# Cathedral Rock Commons Commercial Grading & Erosion Control Plans El Paso County, Colorado

PCD FILE NO. SP221 / SF2210

C:\Users\Owner\Desktop\proj\projects\062102.cathedral-rock\dwg\civil\C3.1.dwg Oct 14, 2022 5:09pm

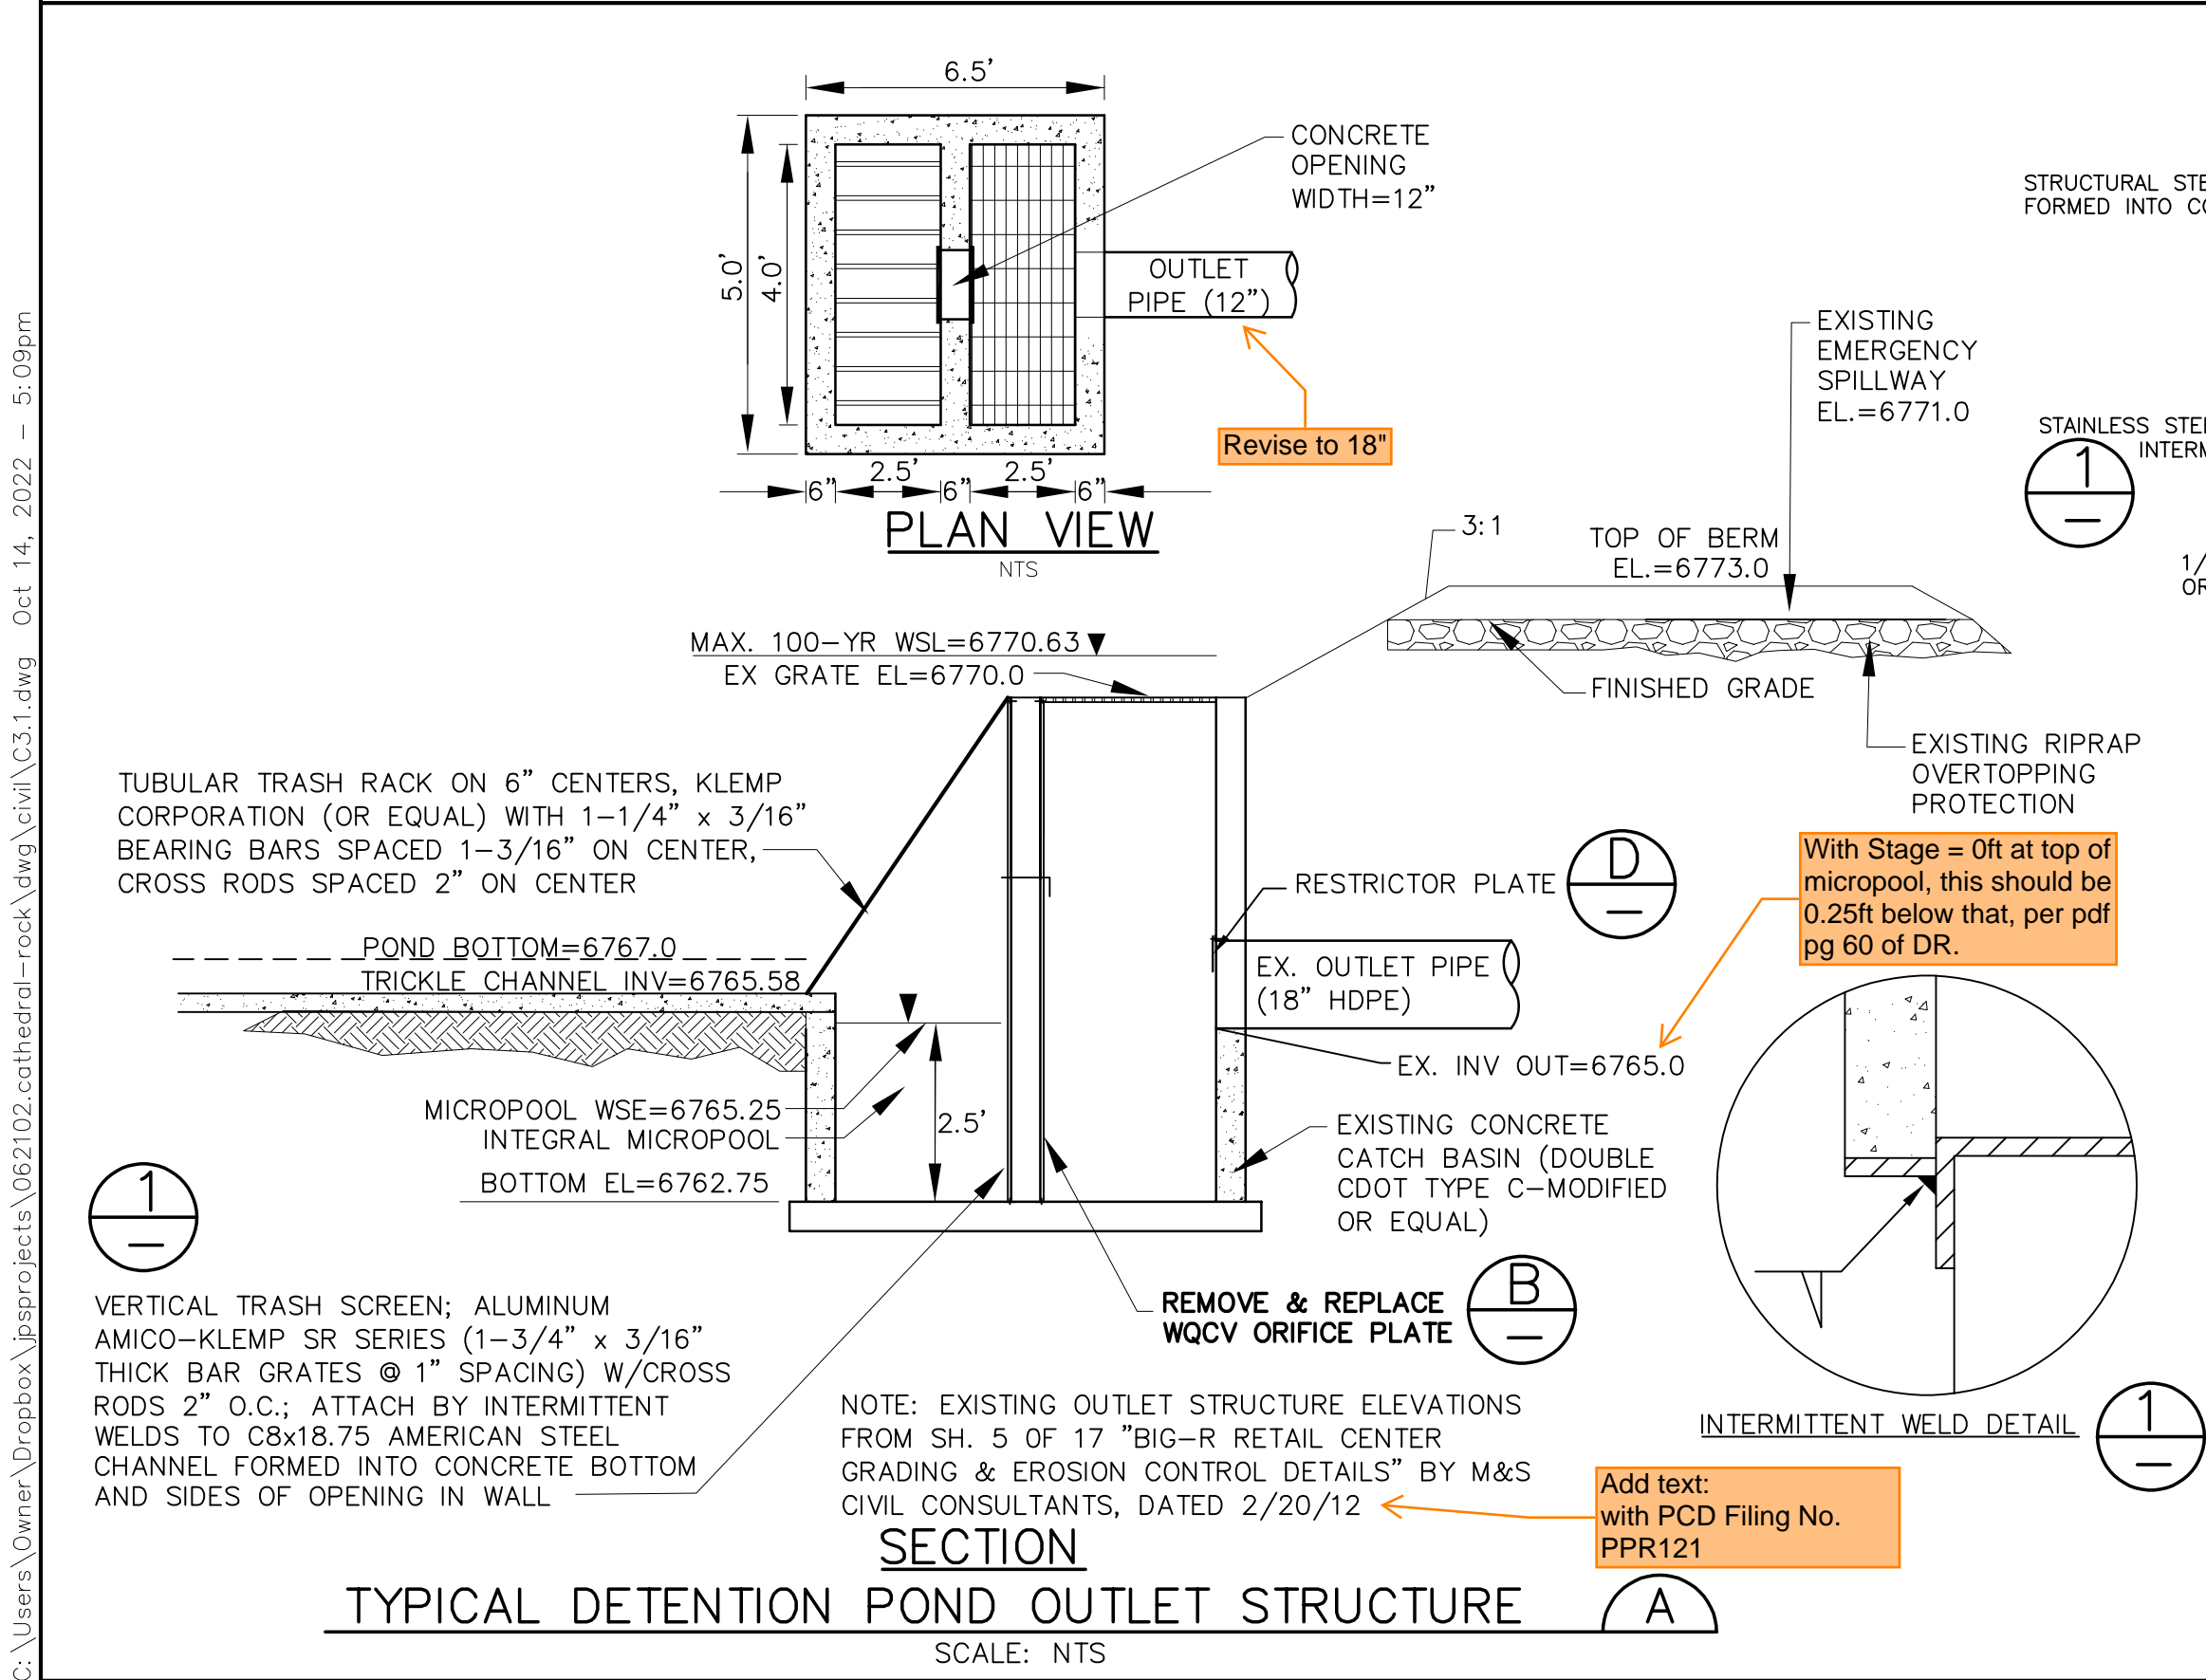
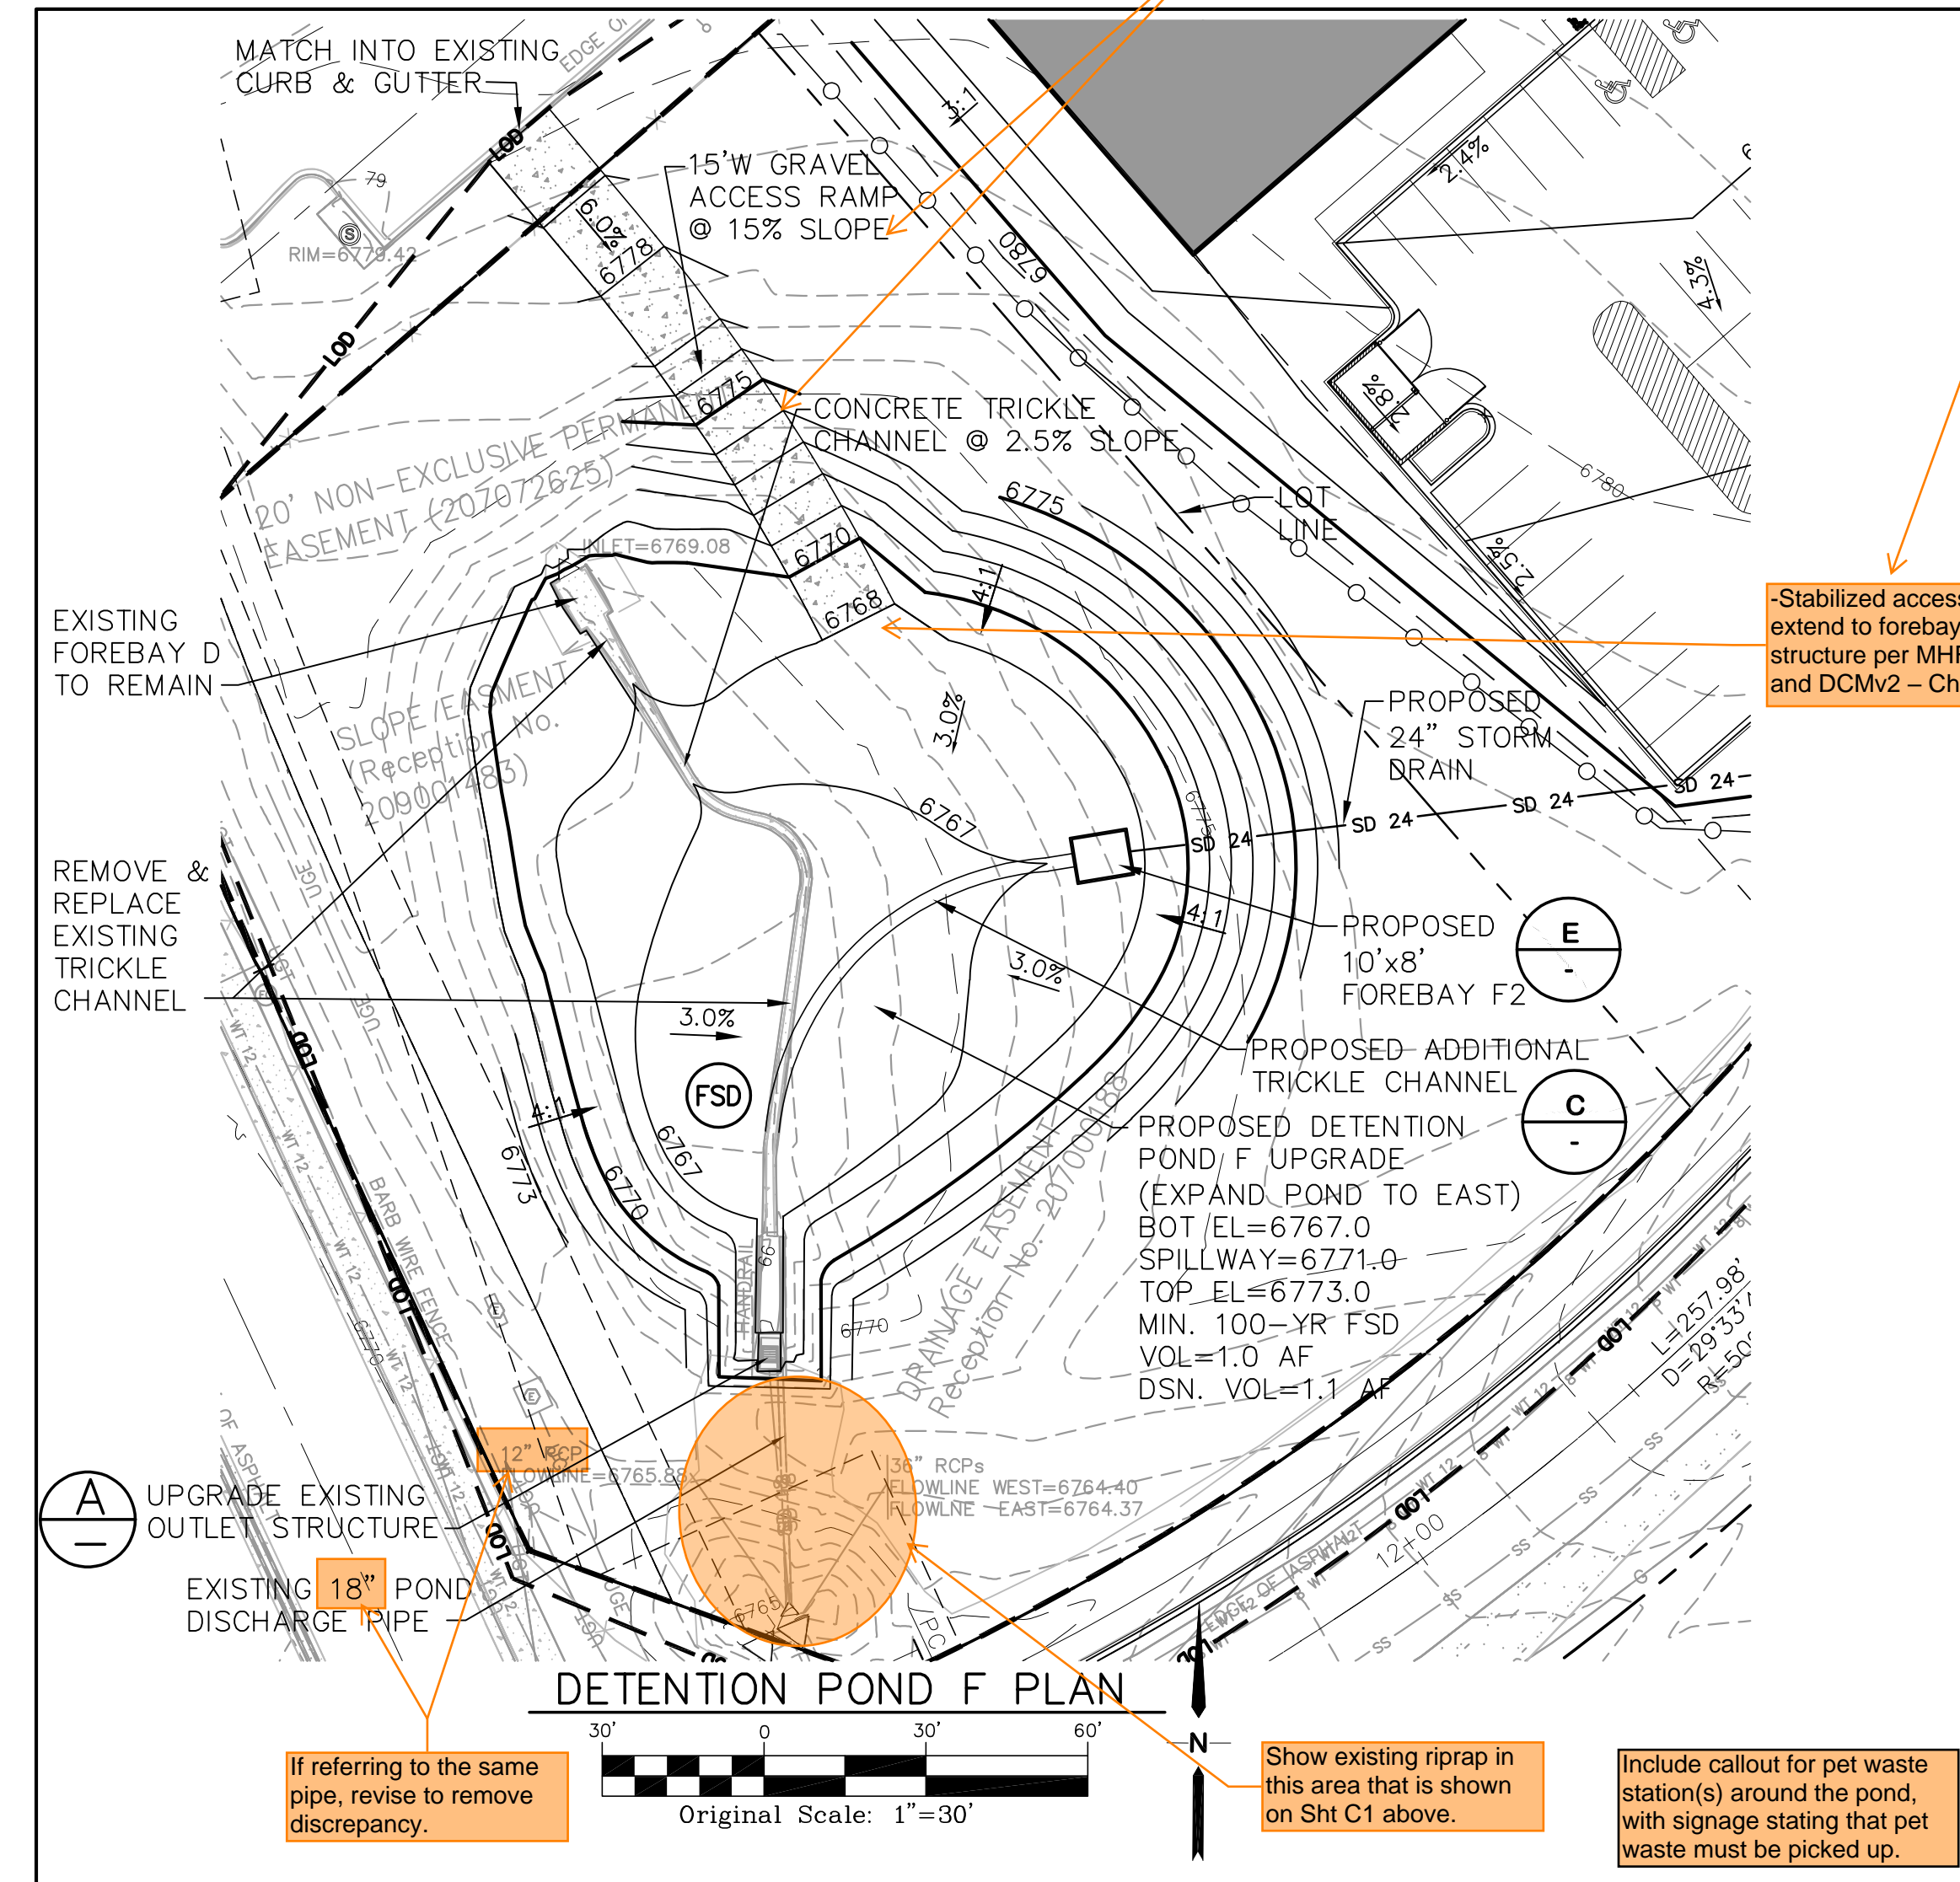
Text callout not updated to say "12%"
